Your Ref: OWPC16795
Our Ref: BR/194/17/PL 30-06-2017
Please ask for:
Richard Temple

Demolition of the existing Foreshore office & decommissioning of existing underground toilets. New purpose built unisex toilet block including urinals, baby changing facilities & accessible WC, plus a separate beach office with public information point & first aid facilities. All located on the existing seafront promenade.

Promenade Opposite Walton Avenue The Esplanade Bognor Regis

DRAWING
Proposed Toilet Elevations

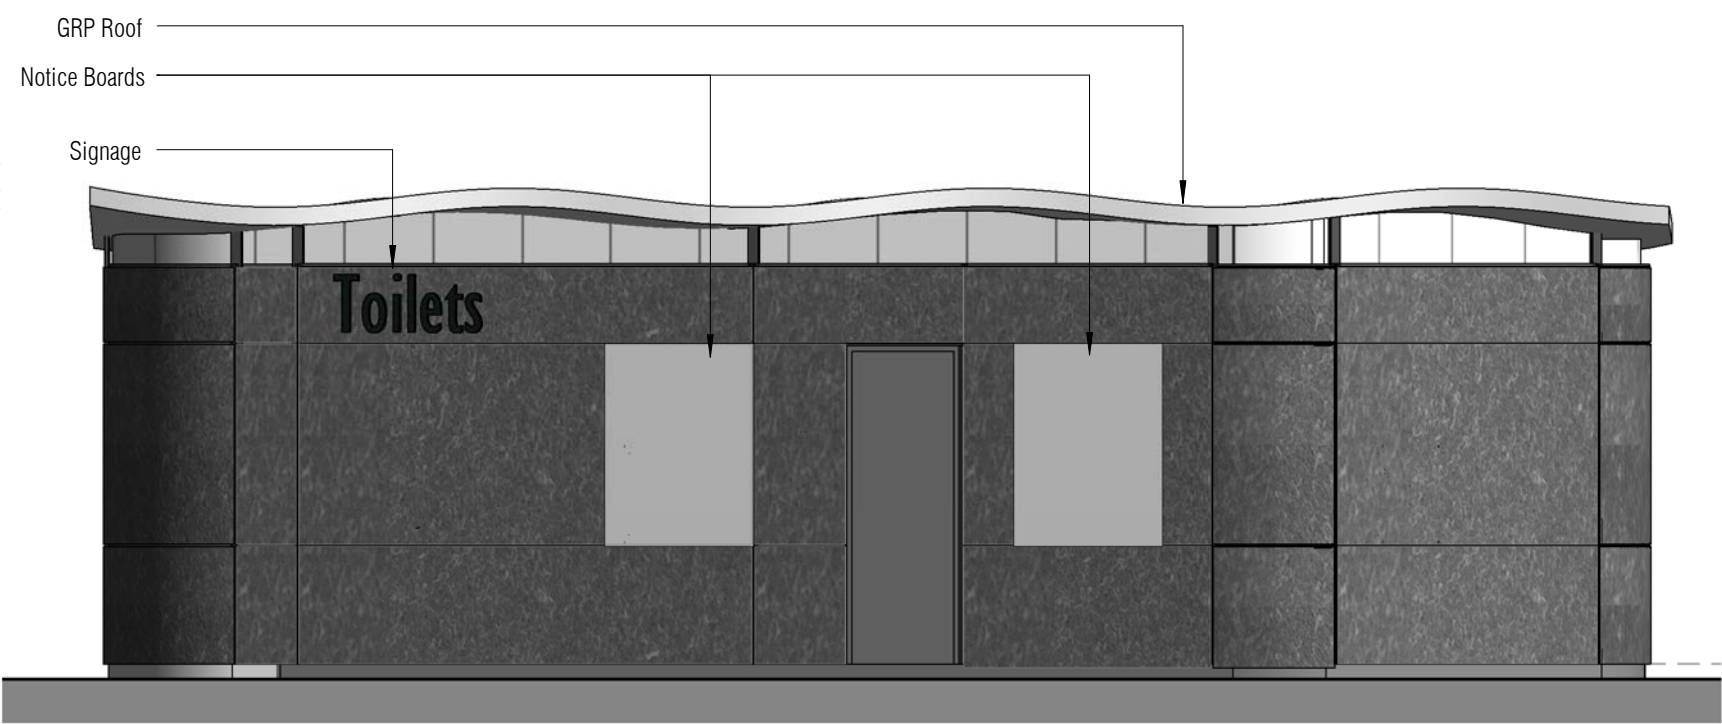
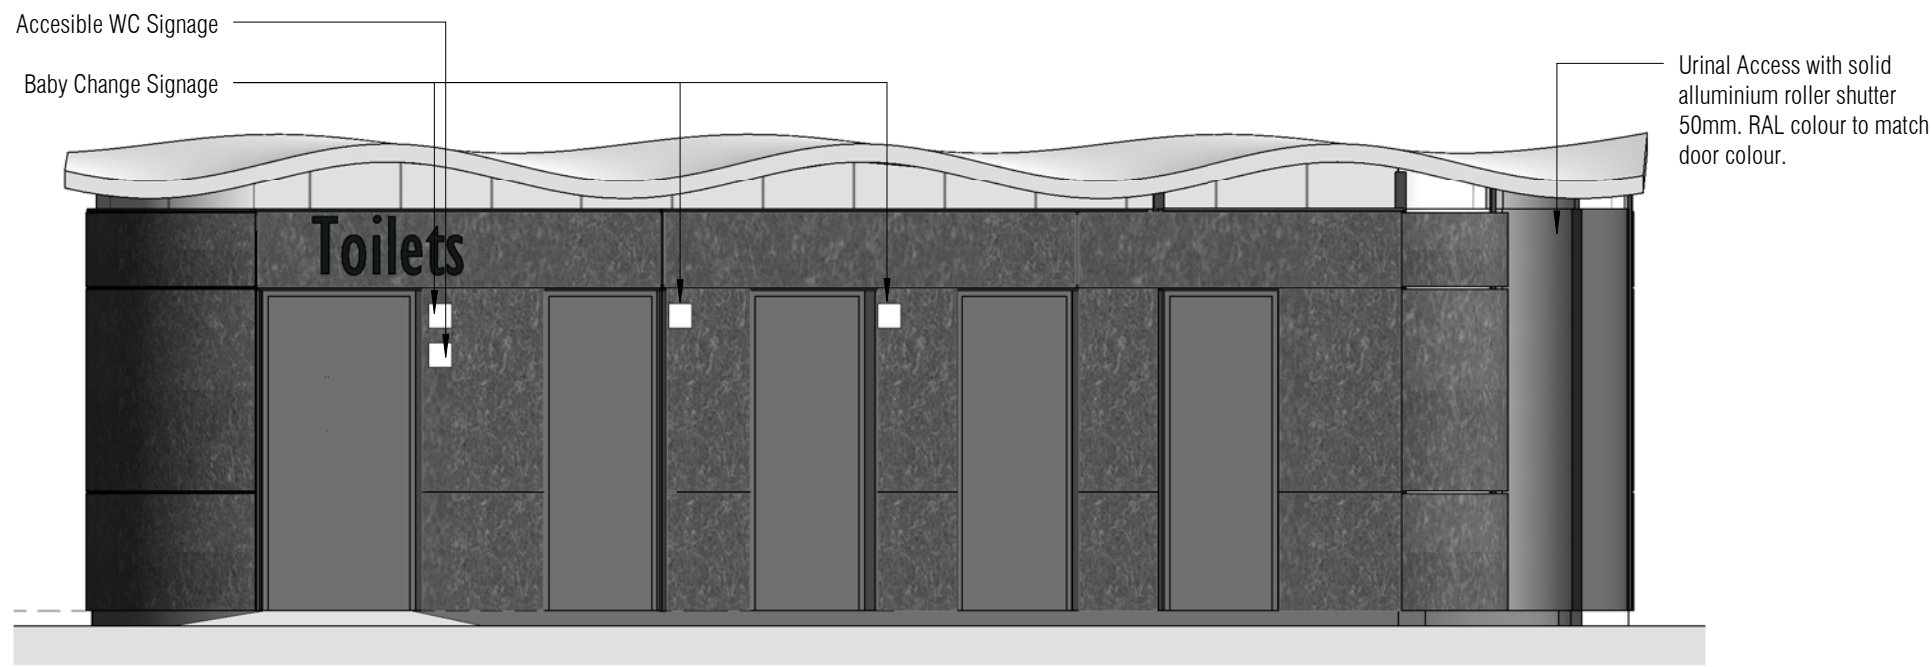
*I feel the oversized toilet signs on the rear of this toilet block
Are totally unnesersary since people using the facilities will be
On the promenade. I feel these cheapen the look of the
Building and should be removed*
